SEAS DEADLINE 6 RESPONSE to APPLICANTS's SUBMISSIONS
SINCE DEADLINE 5, ISH3, Action Points and ExQ3
LANDSCAPE & VISUAL and CULTURAL HERITAGE

PINS Ref: EN020026
DEADLINE 6: APRIL 13, 2026

RE: SEAS Response to Applicant's Submissions since Deadline 5, ISH3, Action Points and ExQ3 – Landscape & Visual and Cultural Heritage

EN020026 SEA LINK DCO – DL6: RESPONSE BY NICHOLAS BRIDGES

**Figure 14. Sea Link EN020026-000343-6.4.2.1 ES Figures Suffolk Landscape and Visual Part 7 of 7, page 7**  
 CUMULATIVE SCHEMES (MAJOR PROJECTS) SCREENED ZONE OF THEORETICAL VISIBILITY - EAST ANGLIA ONE NORTH AND EAST ANGLIA TWO OFFSHORE WIND FARMS

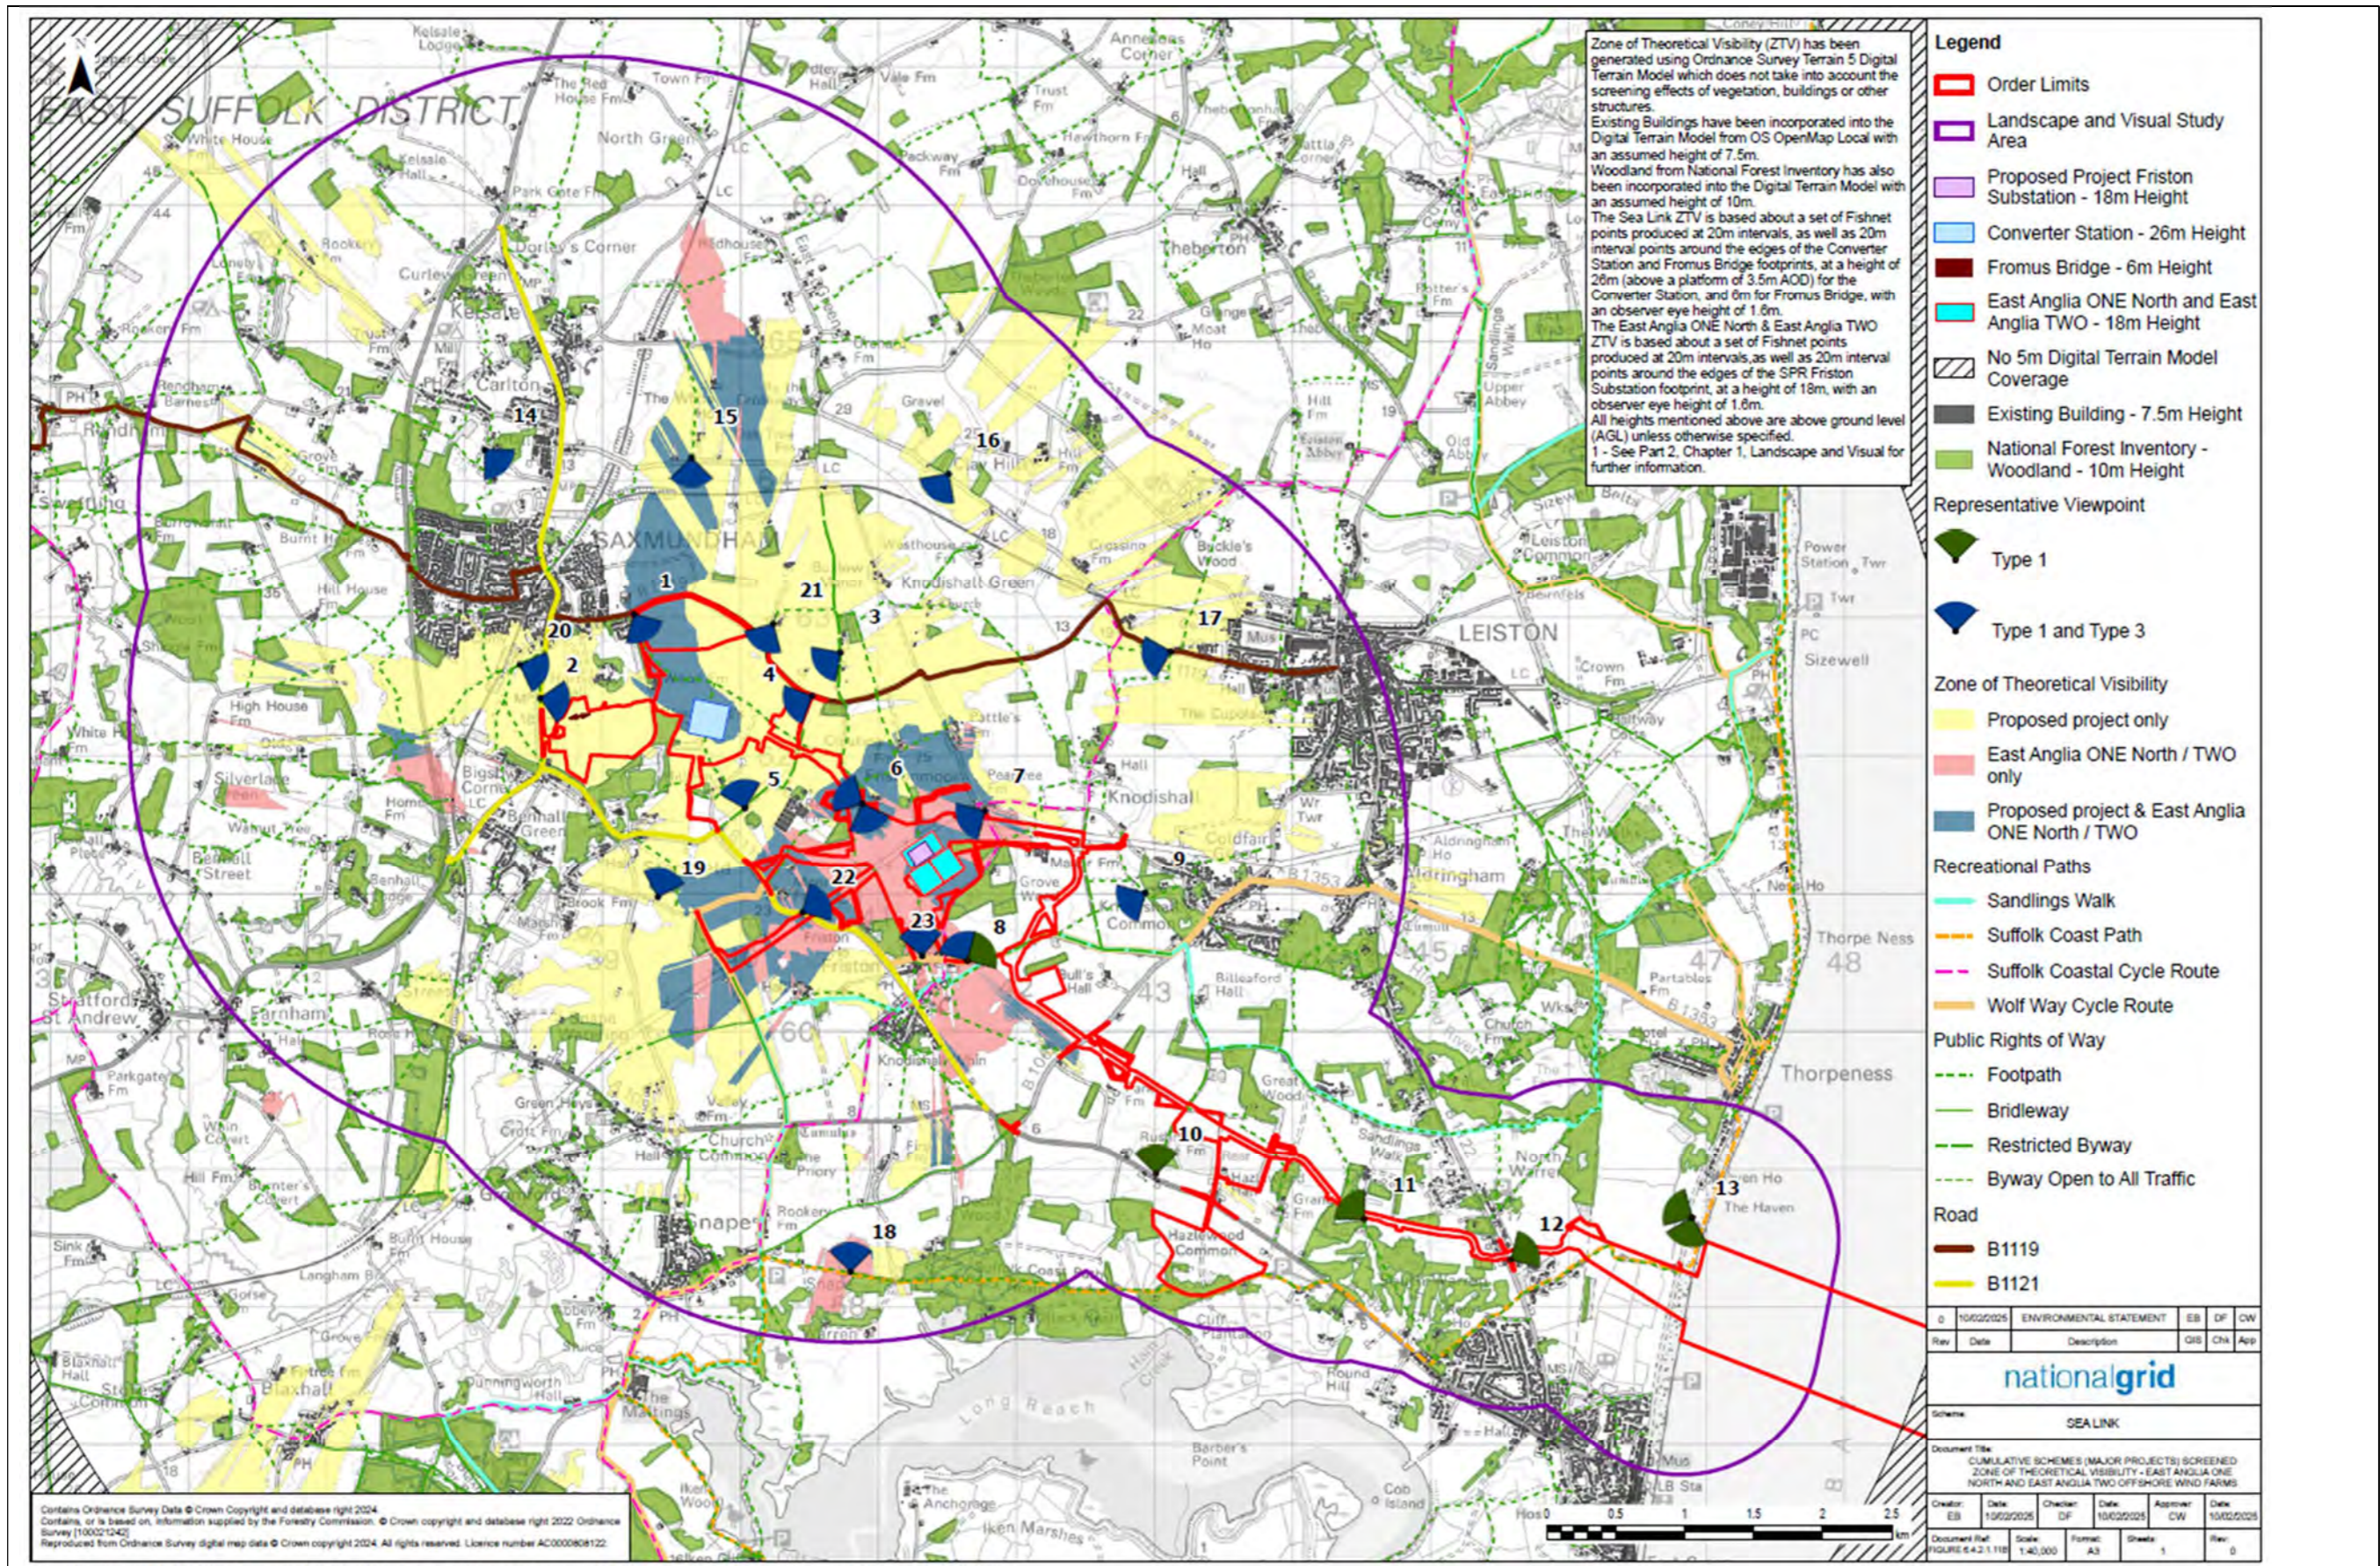
2.10. The 'shadow' patterns illustrate the 'shading' effects of woodland and buildings. The ZTV plans of the same proposed volumetric parameters (**Figures 12 to 17** below) show far less visibility than its PEIR ZTV plans. The accompanying textual details of the model's constraints are exactly the same (see the schedule below).

2.11. The **first question** is: why are the PEIR and DCO plans so completely different? Were the heights in the model changed? Were the shadowing criteria altered? Which is correct? If the DCO is correct, were the EA1N and EA2 ZTVs incorrect? These are simple technical points which can be explained easily.

- 3.1. The submitted DCO ZTV plans should be reviewed for their accuracy.
- 3.2. If they are correct, the applicant must explain why the PEIR was so different
